Application Reference: 2025/0232

Site Address: 15 Hall Farm Grove, Hoylandswaine, Barnsley, S36 7L

This application seeks full Planning Permission for the replacement of flat roof with pitched roof to existing single storey rear extension to dwelling

Drawing Title: Plans, Elevations - Proposed

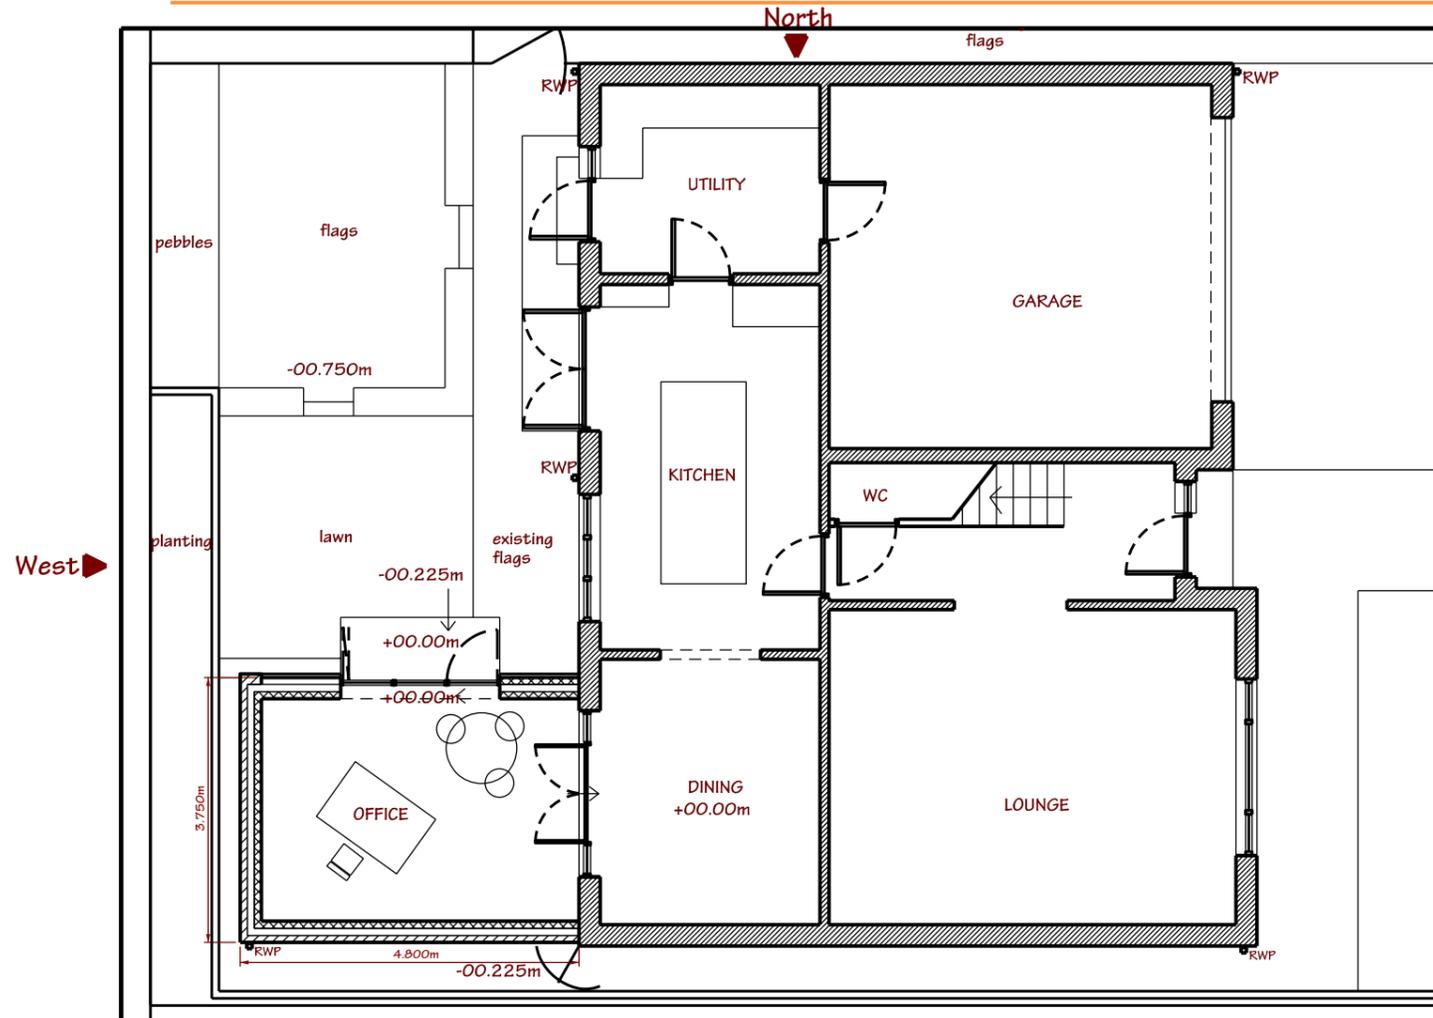
The proposal is to replace the existing flat roof with a pitched, hipped style roof featuring blue slate tiles. The current height of the flat roof is 3m, with its centrally located skylight peaking at 3.27m. The proposed pitched roof would have an eaves height of 2.62m, and a ridge height of 3.82m.

The proposal would increase the height of the existing extension but only by a modest amount of approximately 0.52m or 52cm. As with the previous maximum height, this peak height would be concentrated near the centre of the roof, this time at the ridge, where previously at the sky lantern. The proposed eaves height of approximately 2.62m would be lower than the original flat roof which stood at 3m, with the proposed roof now gaining height towards the ridge. With an effective boundary height of 2.8m, the eaves of the roof would not be overtly visible for No.11, and only the highest 102cm (1.02m) of the extension would be clearly visible above the hit and miss boundary fence. With no new windows proposed within the extension, there would be no concerns over privacy, and the overall impact of the proposed extension would be limited in respect to No.11. For other nearby dwellings, the modest size of the extension and the distance to other dwellings ensures there would be little or no impact on their amenity.

Whilst no concerns have been raised, and although a premium product of blue slate is proposed for the new roof, instead of matching generic grey tiles, this does not confirm to the usual policy requirement of materials of a similar appearance to those used within the construction of the main dwelling. However, with limited public view, and the extension already featuring a painted or rendered section, the proposed materials would have little or no impact on the design of the extension and any impact on the character of the original dwelling would be outweighed by the improved roof design. Therefore, the impact on design and character of the dwelling would also be deemed to be limited.
